Viking CCS Pipeline

**Environmental
Statement Volume IV –
Appendix 5-3:
Response to Scoping
Opinion**

Document Reference: EN070008/APP/6.4.5.3

Applicant: Chrysaor Production (U.K.) Limited,
a Harbour Energy Company
PINS Reference: EN070008
Planning Act 2008 (as amended)
The Infrastructure Planning (Applications: Prescribed Forms
and Procedure) Regulations 2009 - Regulation 5(2)(a)
Date: October 2023

LEGEND

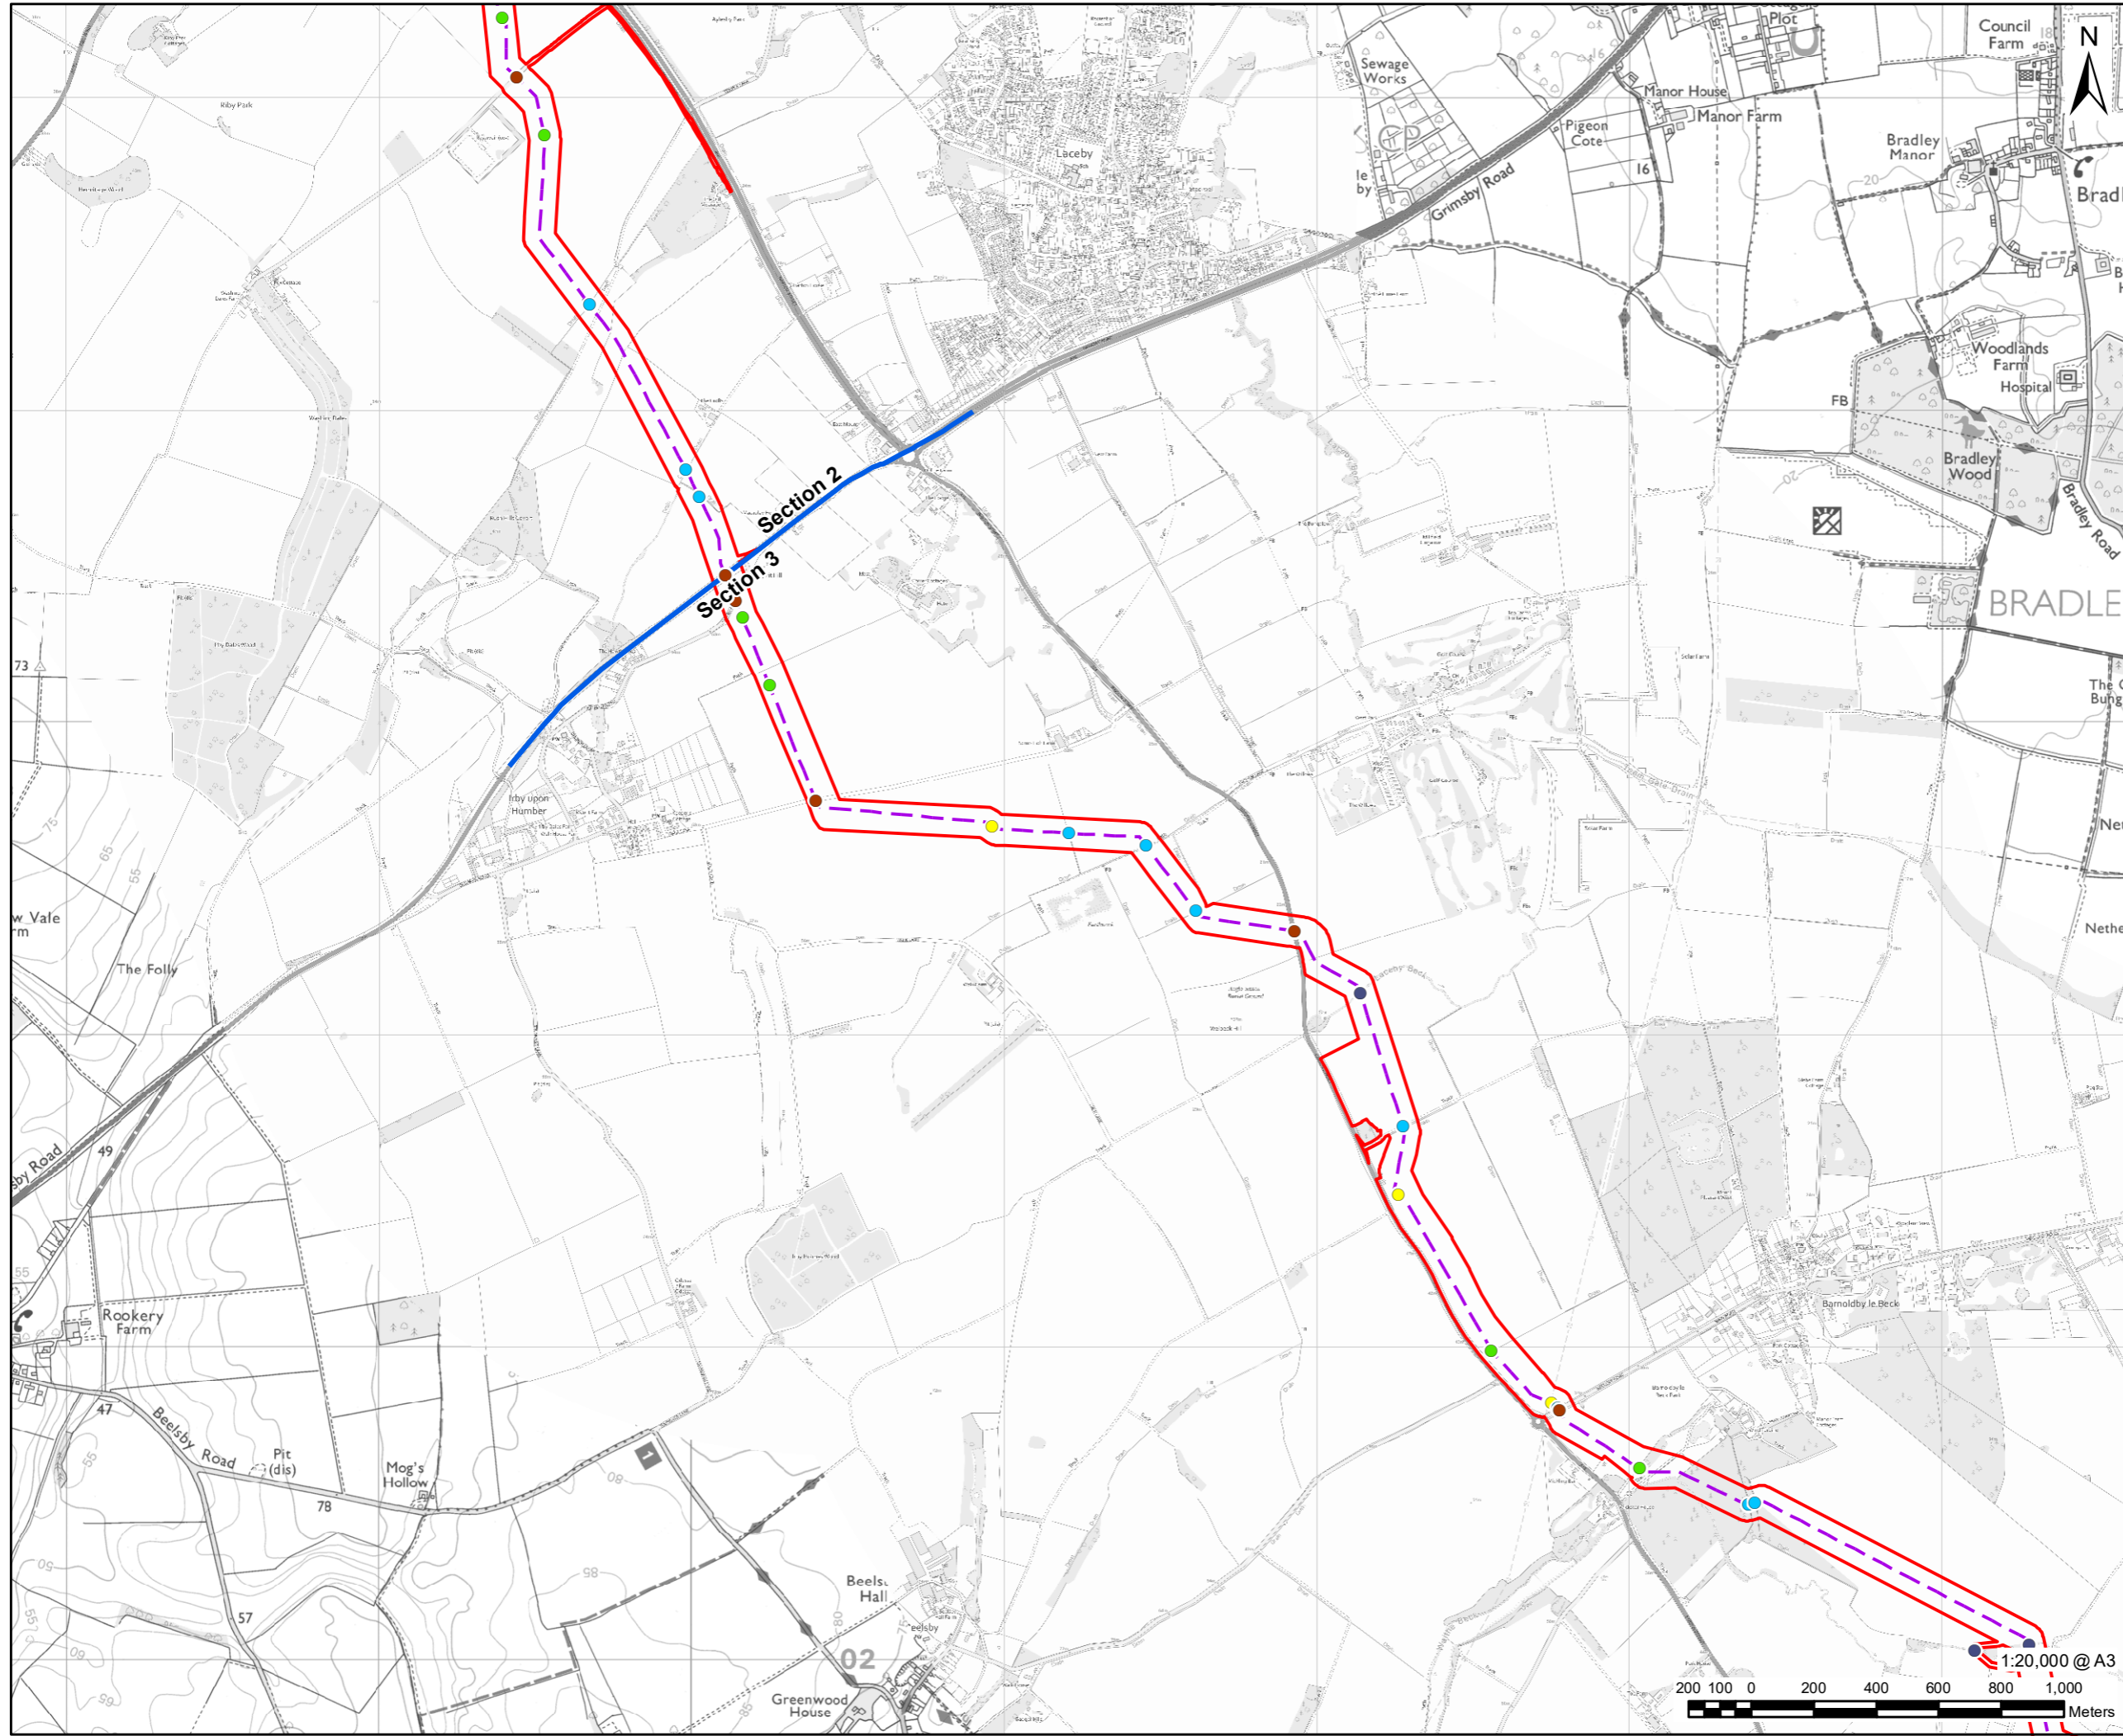
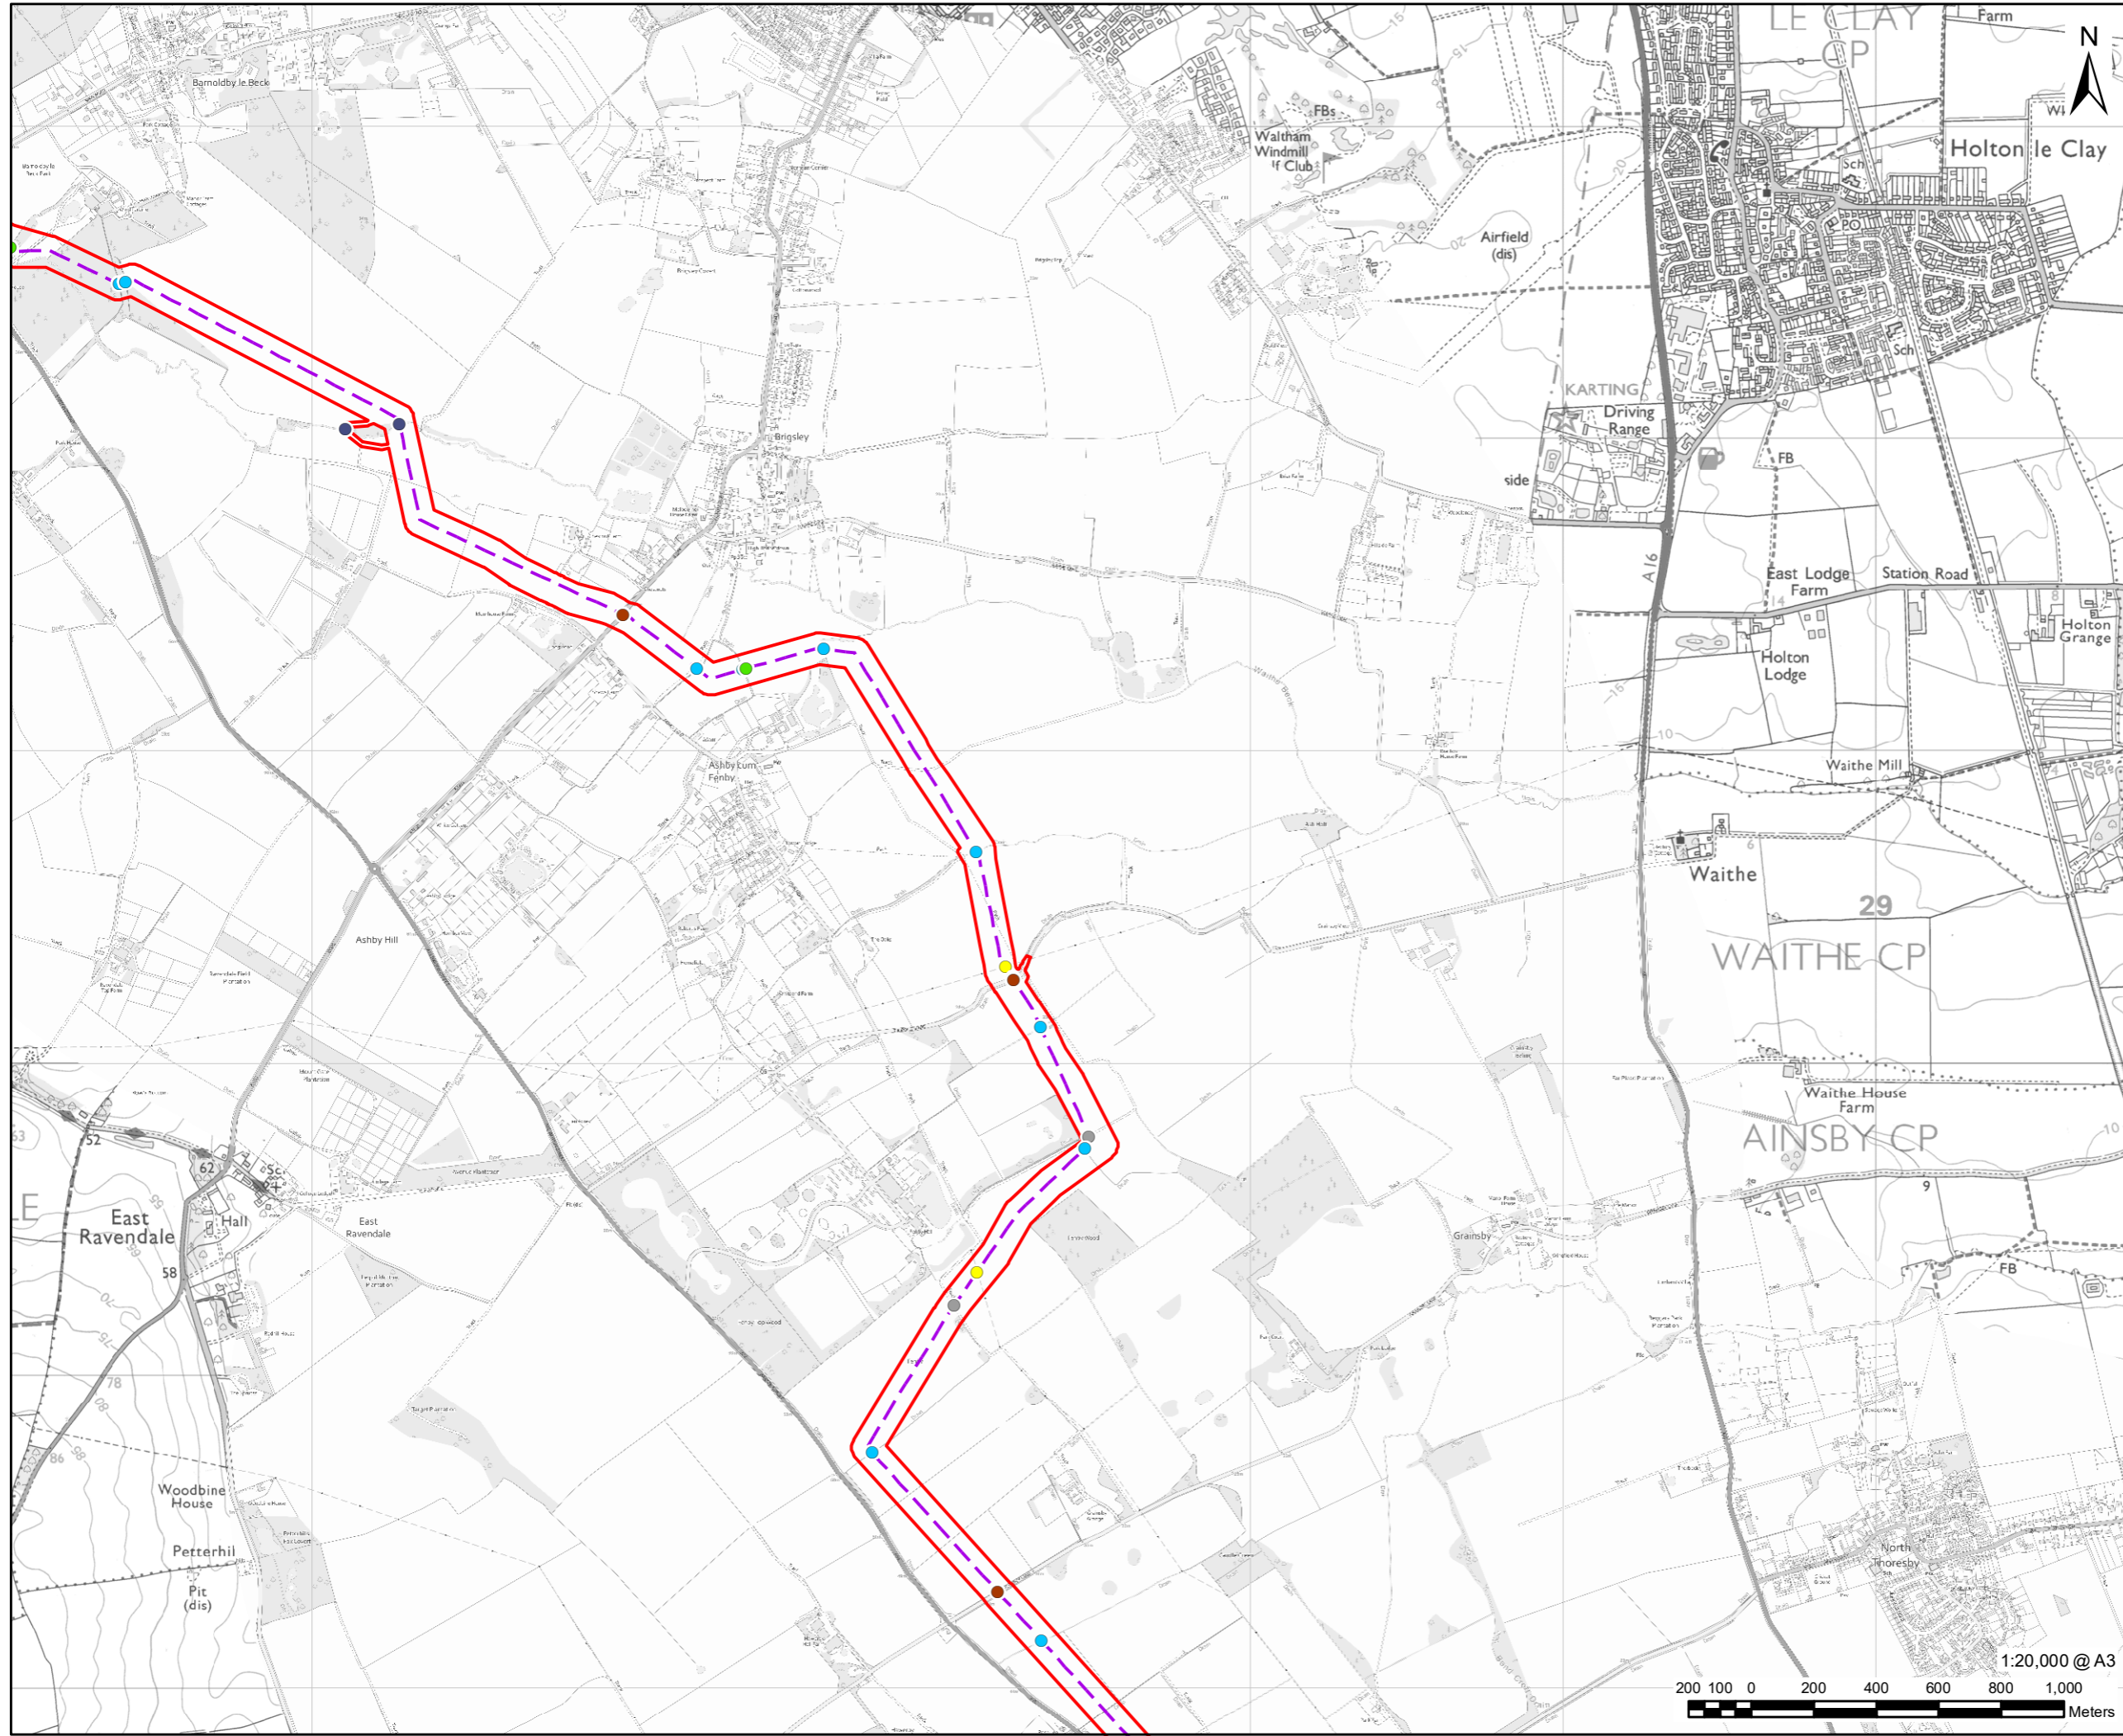
2.1.3	Section 2.5, 2.15	Pipeline crossing methodology	Paragraph 2.5.20 explains that open cut trench installation is the likely crossing method to be adopted, with consideration given to trenchless techniques in particular locations. The further information in Table 2-4 and Section 2.15 is noted. Where a particular installation method at a particular location is committed to or assumed for the purposes of	<i>ES Volume IV Appendix 3.2 Crossing Schedule (Application Document 6.4.3.2)</i> details each crossing required for the Proposed Development as well as the method in which it will be crossed, whether open cut or trenchless. These are displayed

ID	Ref	Description	The Inspectorate's Comments	Applicant's Response
			assessment, this must be clearly explained in the ES and secured in the dDCO.	in <i>ES Volume III Figure 3.9 (Application Document 6.3.3.9)</i> .
